From: Nicola Spencer
Sent: 20 June 2017 12:54
To: Karen Parsons
Subject: FW: Fitzalan Link - LU.234.16.RES

As set out in Tim's email, there are three points that need to be addressed, the rest of the issues are detailed design issues. Please could you let me know what your response to the issues is so we can progress the application. If a different surface is being proposed to the one that was modelled then the modelling will need to be revised. Please could you also agree an extension in time until the 31st July in order to allow sufficient time for revised plans to be submitted and considered and the updated Safety Audit to be submitted and reviewed by WSCC.

Following review of the submission, WSCC comments as follows:

In summary, there appear to be just three outstanding points now – the choice of road surface, the requirement for a new or supplementary Stage 1 Road Safety Audit and the design of the shared footpath-cycleway connection to Highdown Drive close to the new Toucan crossing now proposed. The other points can be tied-into the detailed S38/S278 submission.

| title  | PUBLIC RIGHT OF WAY DIVERSION PLAN |

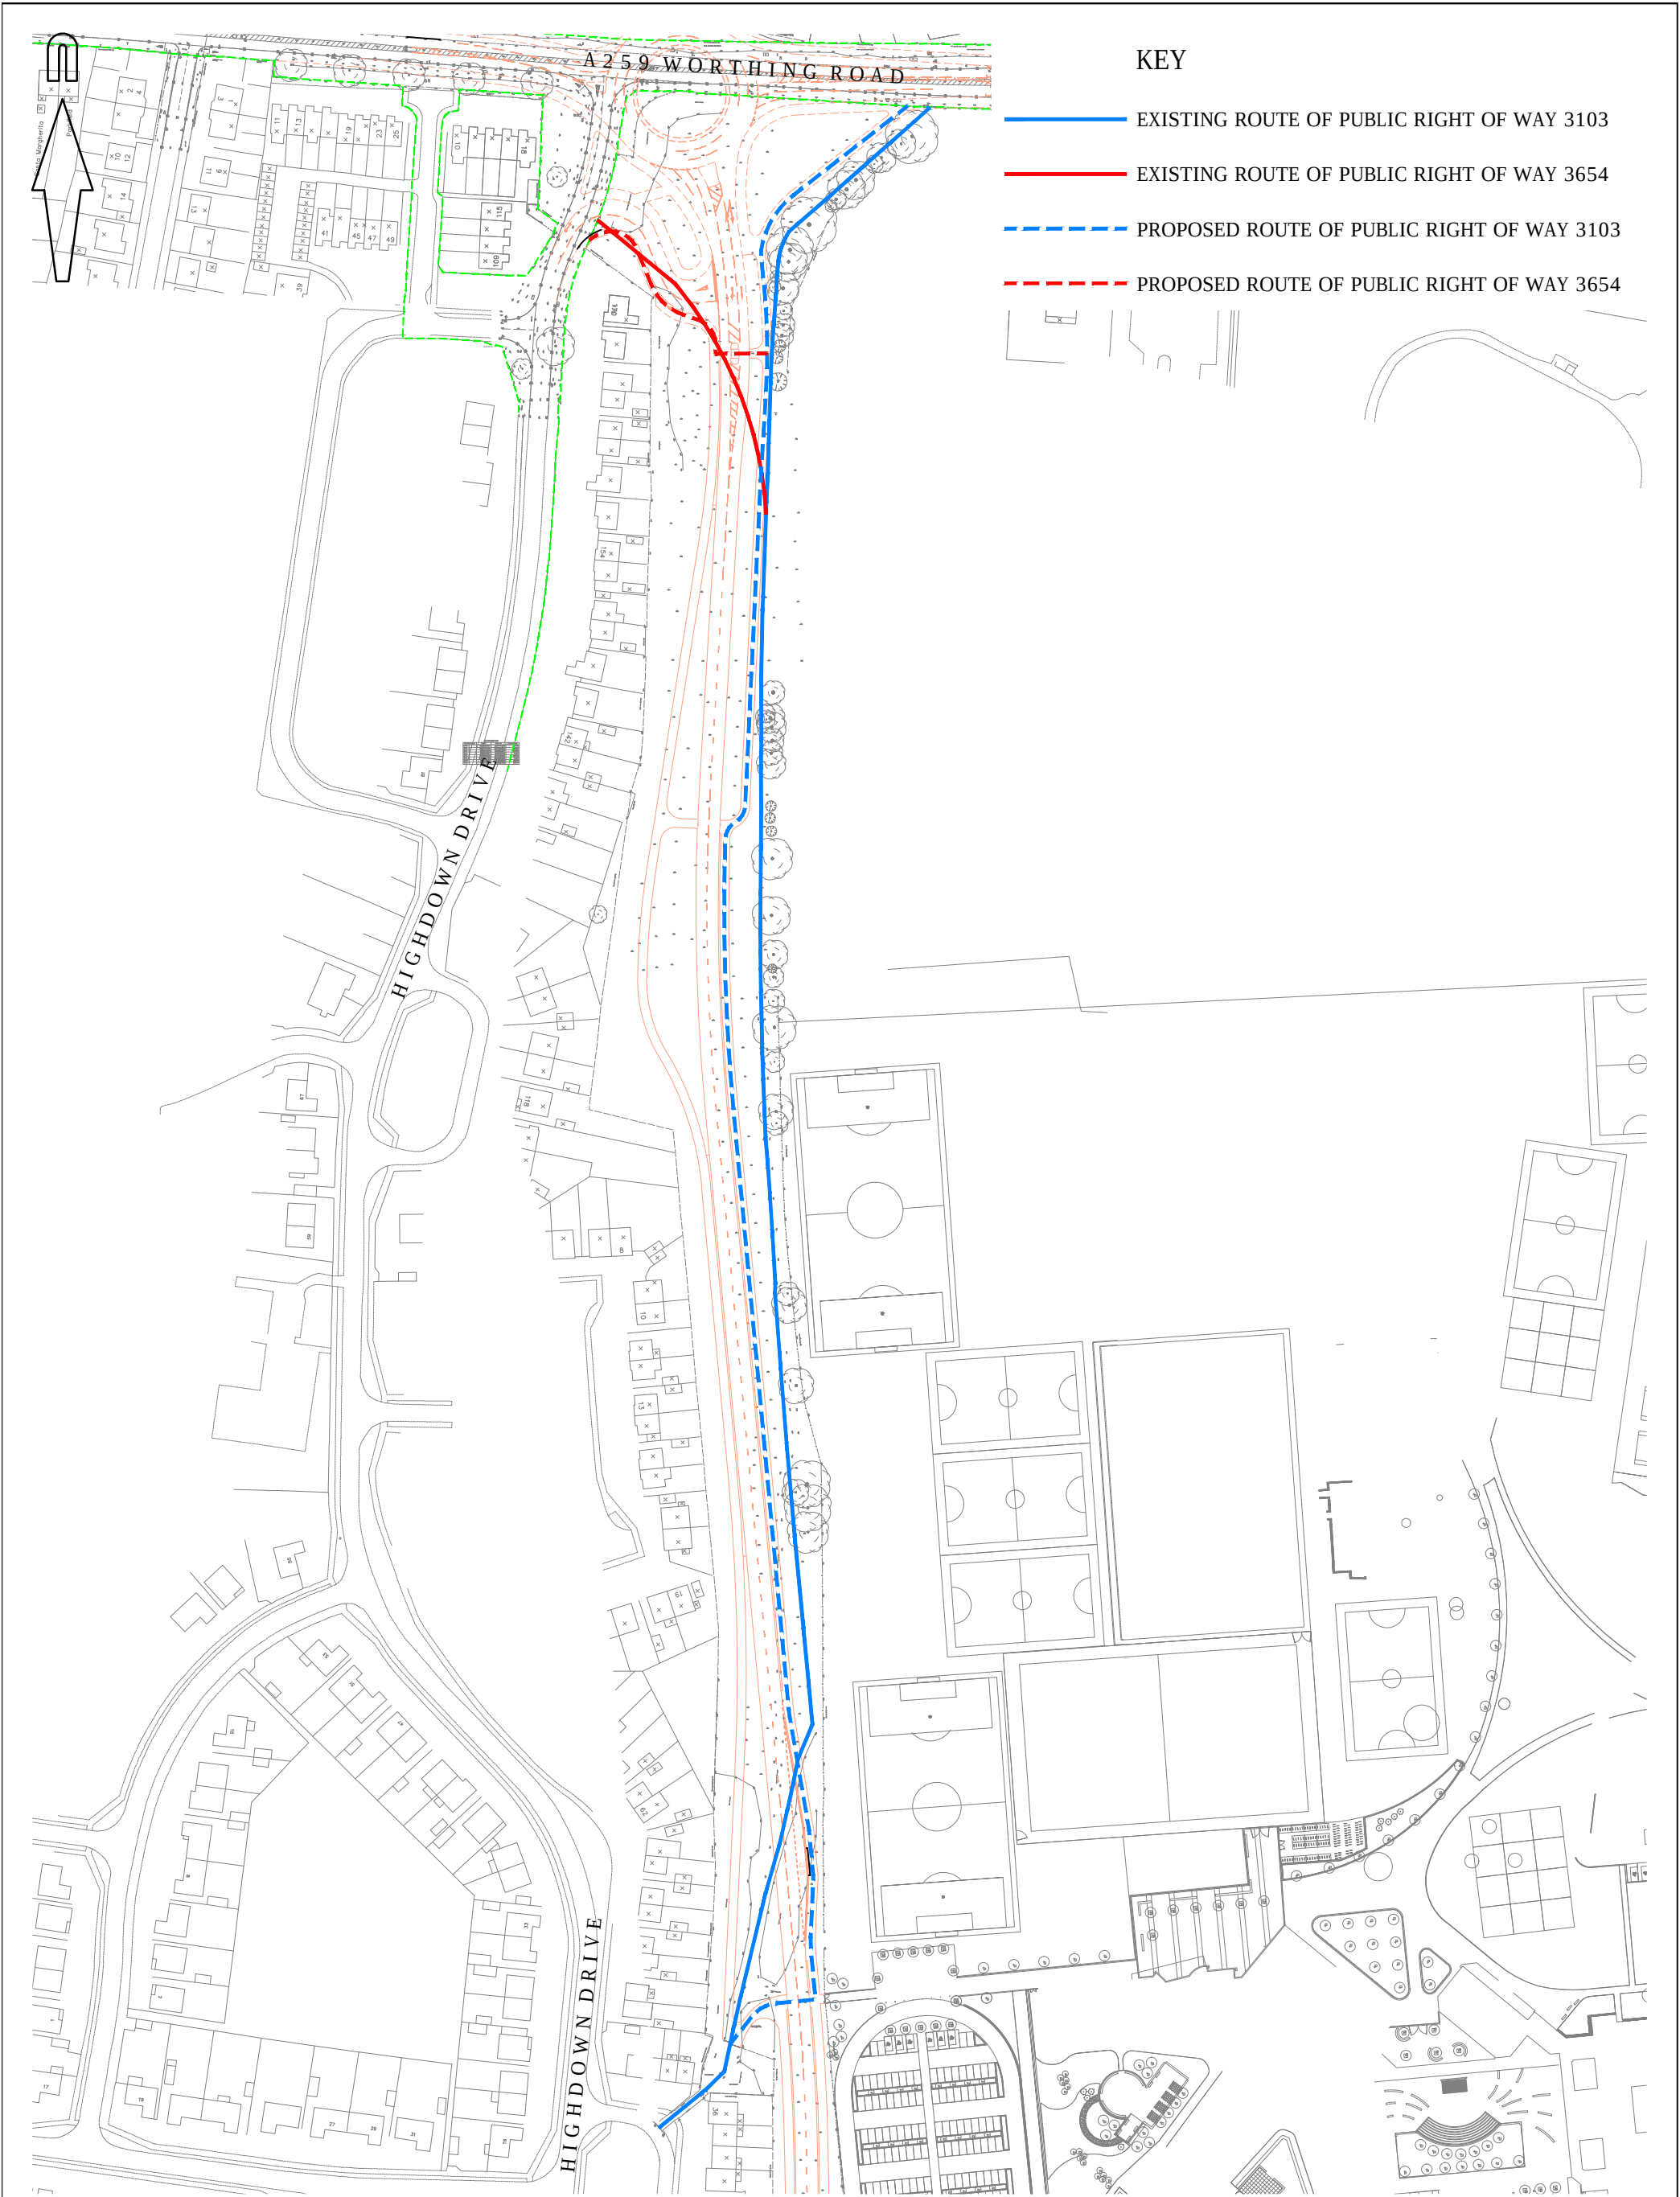
You have again offered an explanation for the path alignment in the vicinity of the Toucan crossing and balancing pond. The radii proposed are acceptable to us but the path must connect properly to the path leading to Highdown Drive which should be upgraded to a shared footway-cycleway. I have indicated below what this might look like. However, looking at this again shows the pink area to be public highway and on the line of part of Public Footpath 3103. Therefore, it is recommended (and indeed appears more straightforward) to retain this line otherwise it appears that any continuation of the route south of your scheme might cross land that might not be highway. Any path should be lit, edged, resurfaced, signed and tactile-paved appropriately although these final details can be shown at the S38/278 stage. Any upgrade from Public Footpath to shared footpath-cycleway must be undertaken in-accordance with WSCC PRow procedures.

Any changes to formal PRoW (temporary and/or permanent) must only be undertaken following appropriate WSCC processes and/or procedures and obtaining all necessary permissions – some of which are often separate from any planning application processes. Full details can be obtained directly from the PRoW team here at WSCC.

With regard to the PROW this had been discussed extensively before, essentially I can't make the diversion application until PP is granted. But I am aware of the processes and will follow all necessary processes at the relevant time. I will try and dig out previous correspondence and re-send it to you. I think Hilary previously emailed on this matter so it may be that you don't have a record.
